**CITY OF ALBUQUERQUE
PLANNING DEPARTMENT
February 12, 2014
DRB Comments**

PROJECT # 1006902

APPLICATION # 14-70031

RE: La Luz del Oeste Unit 4

PLAT OF LOTS K-1-A & K-2 THRU K-10  
LA LUZ DEL OESTE, UNIT 4

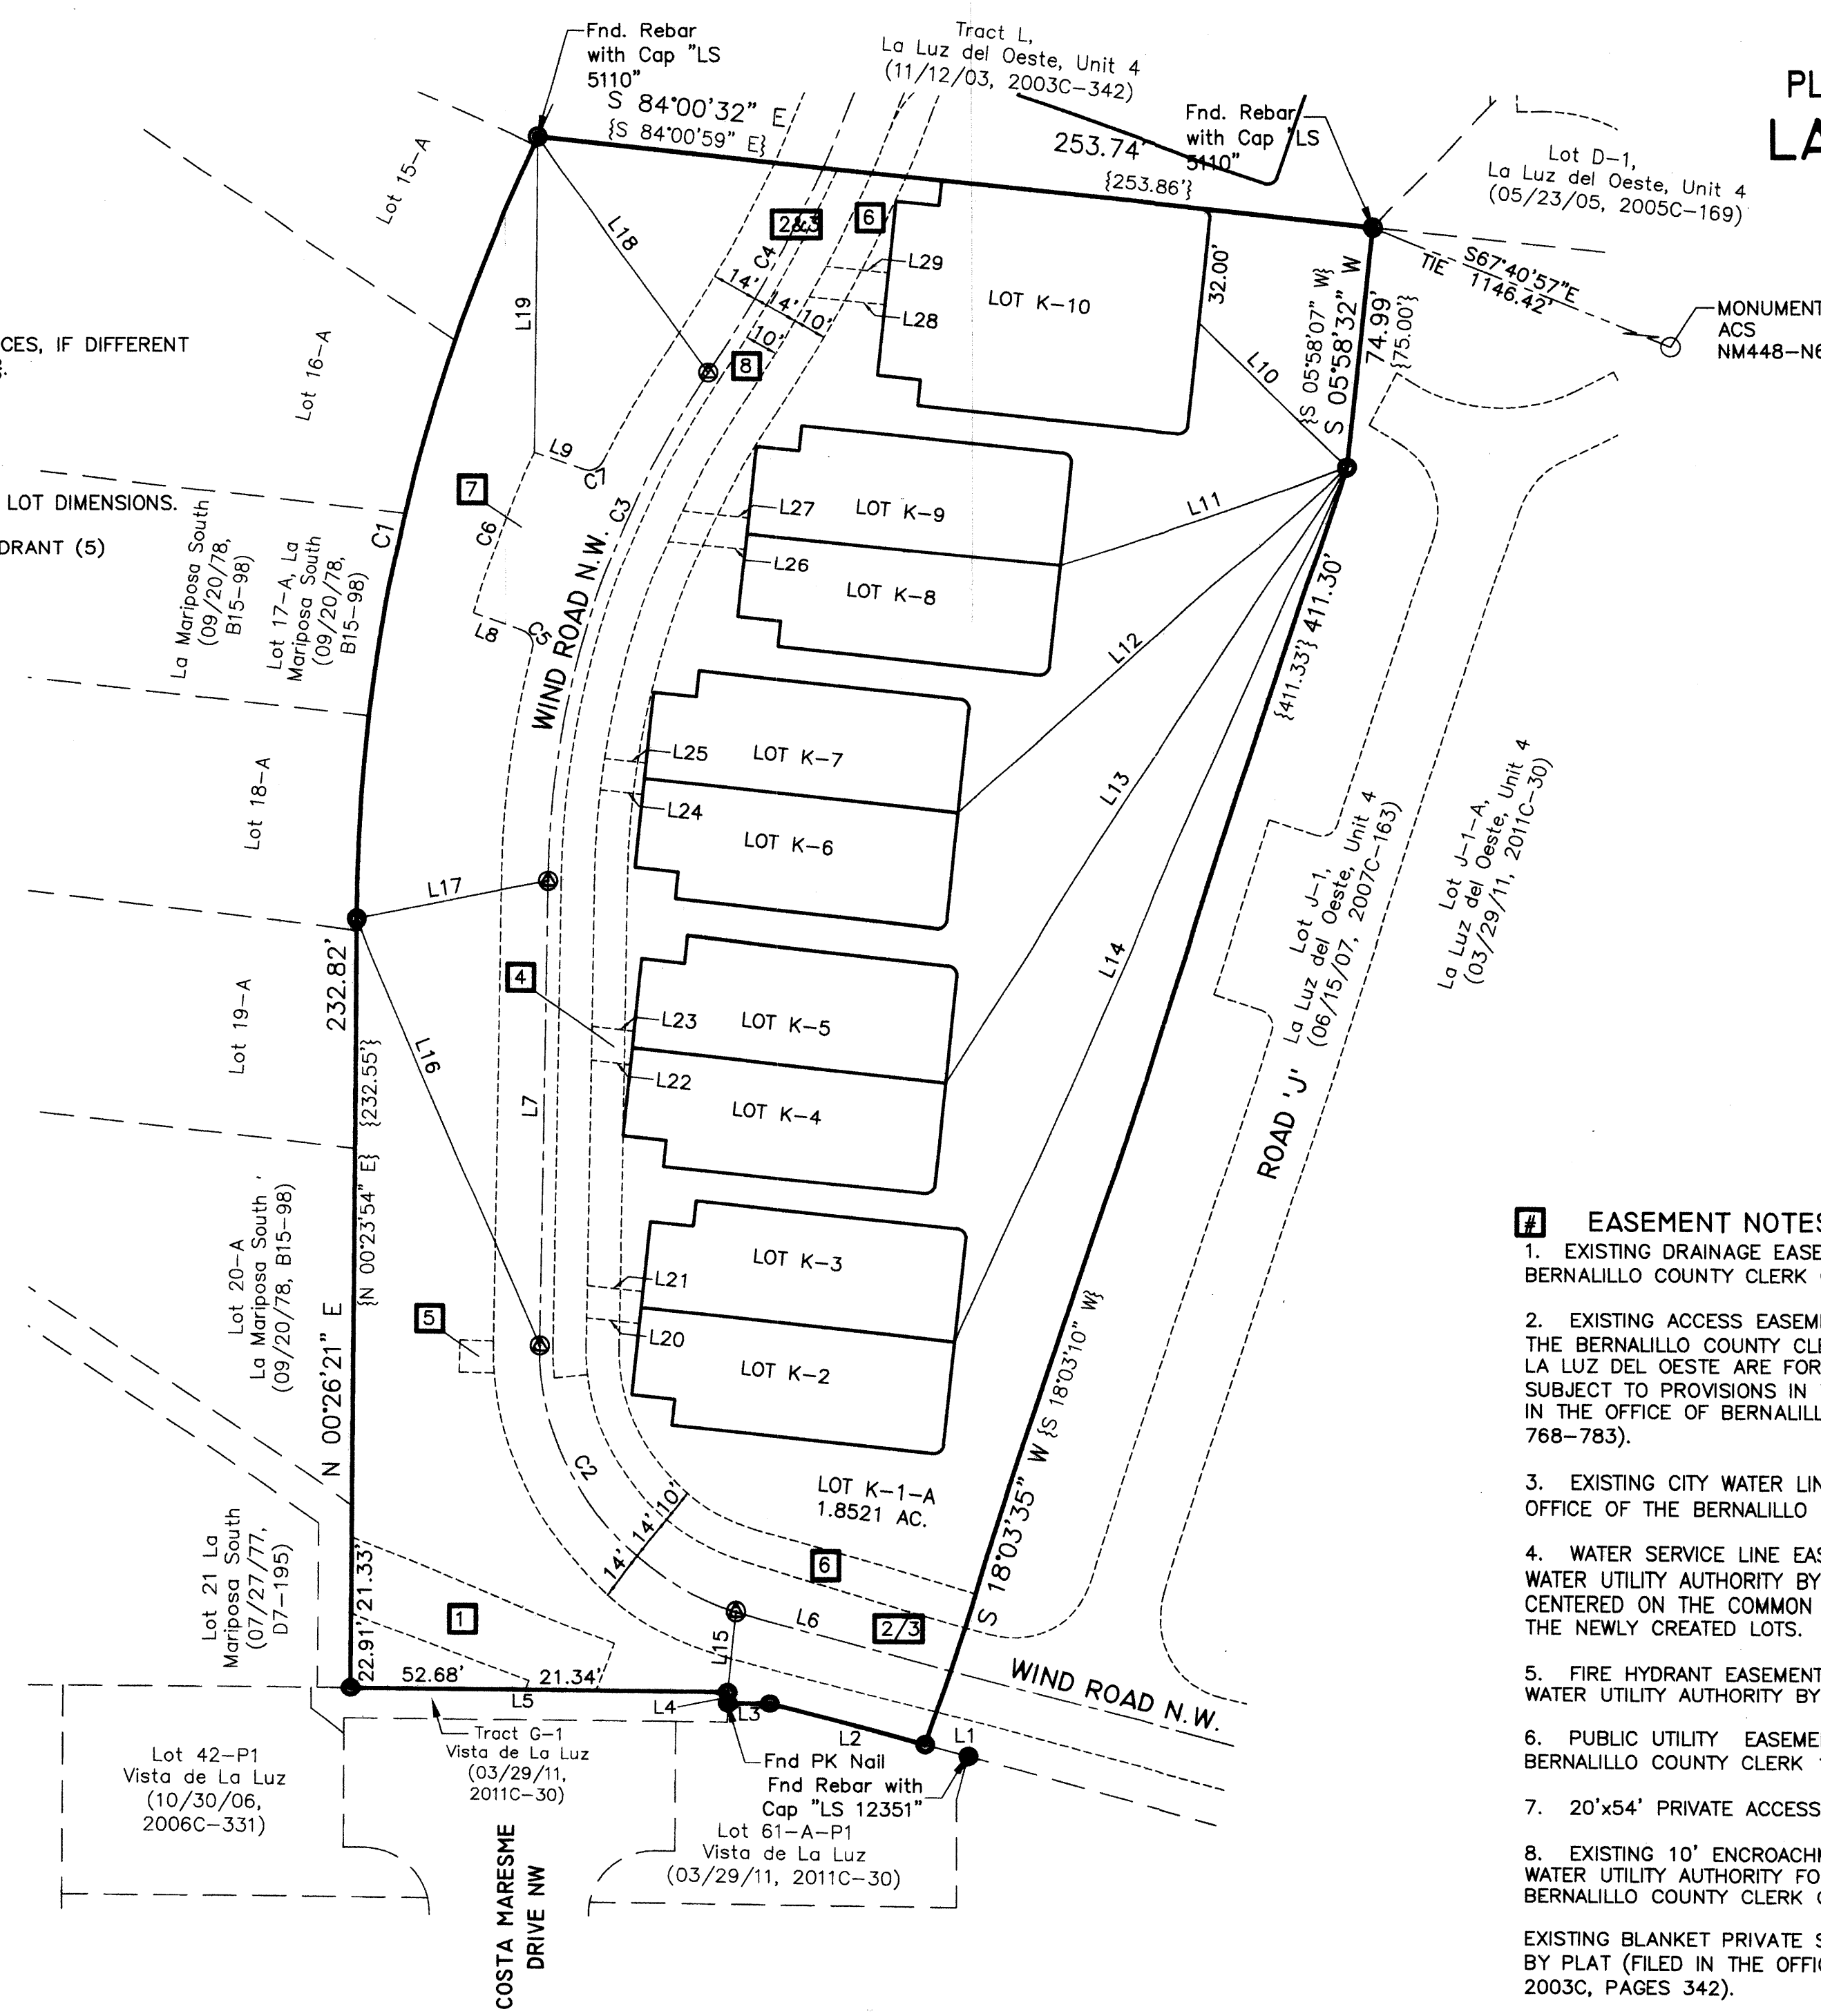
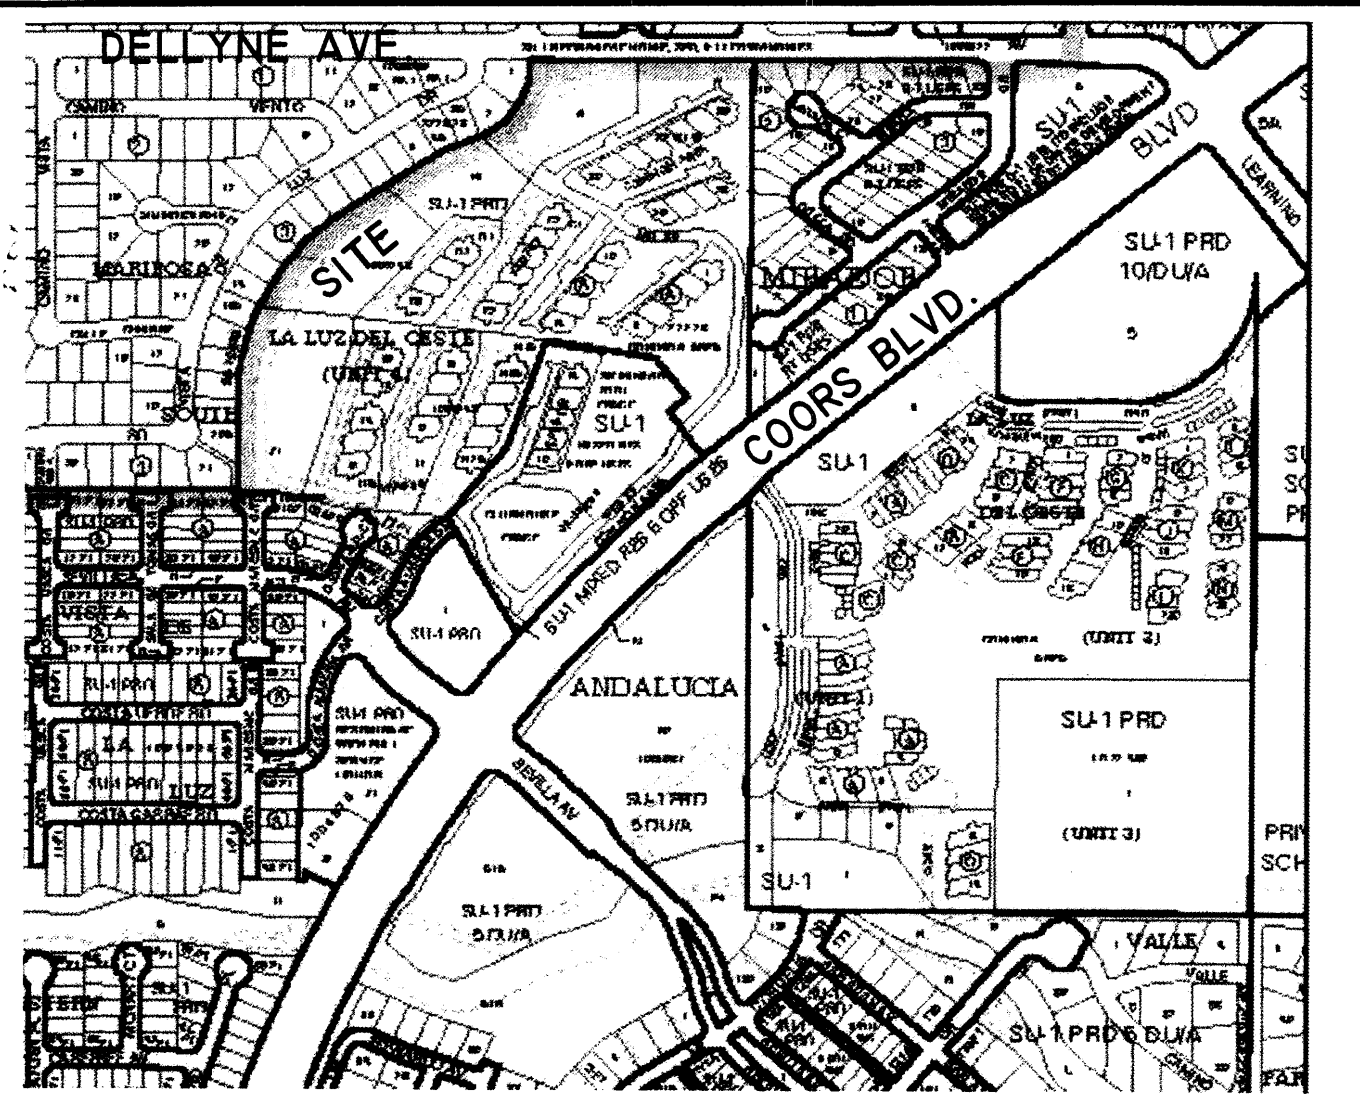
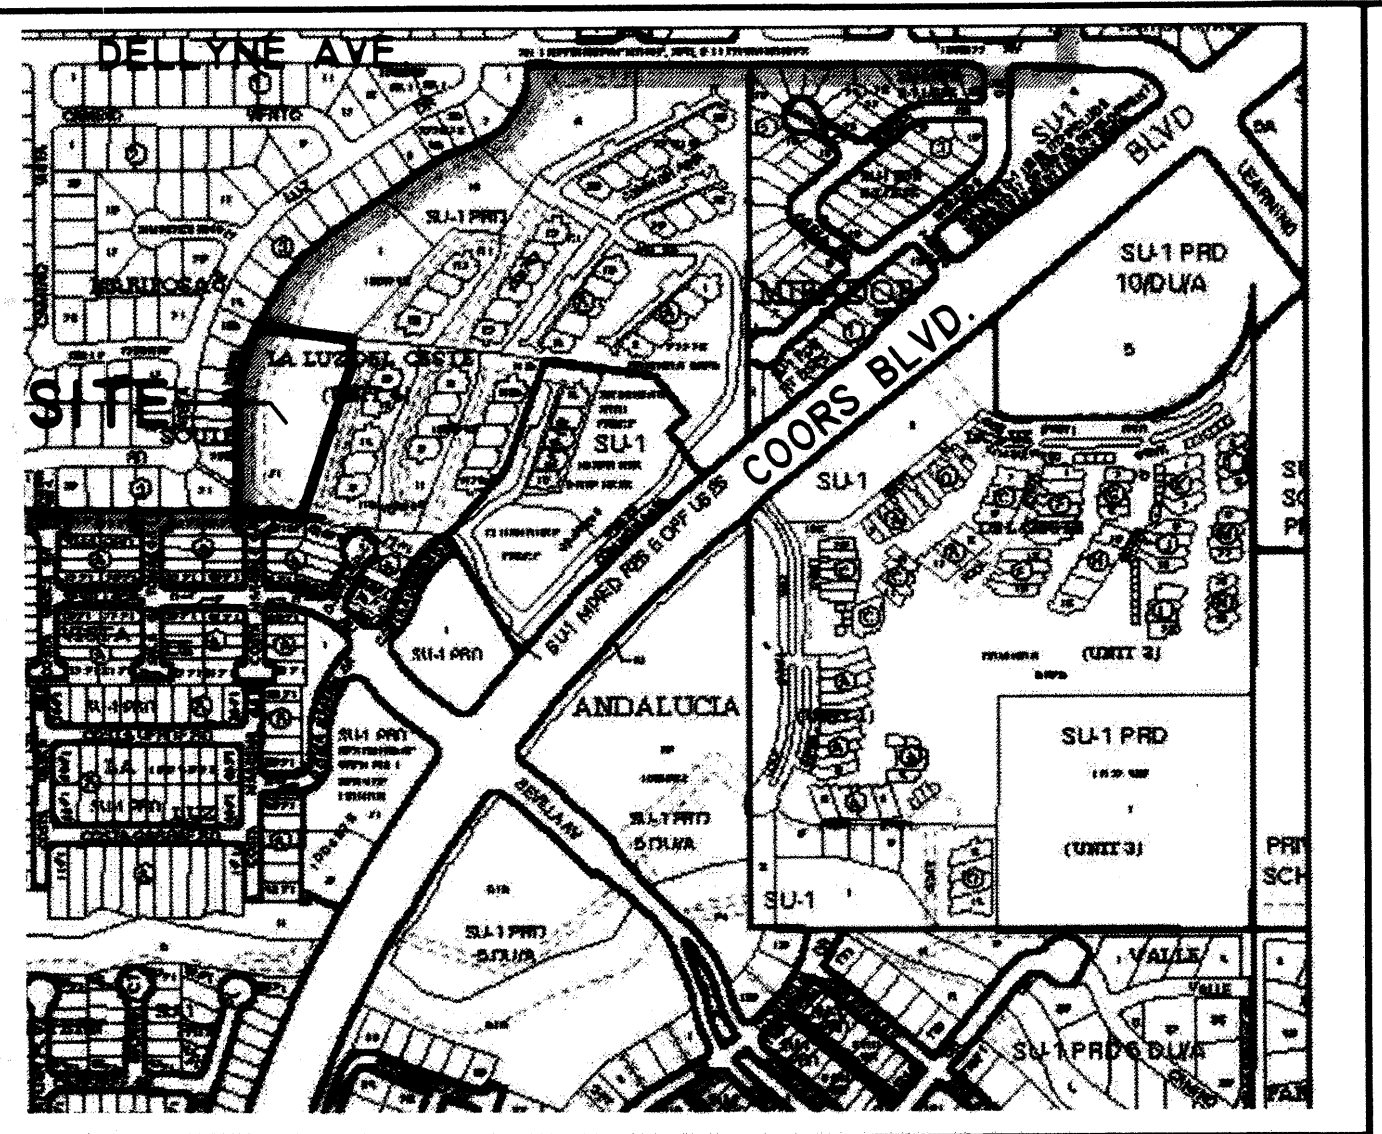
There appears to be a lot line thru Lot 10; this should be removed pending future replat.

Off site turnaround easement needs to be recorded and referenced on this plat.
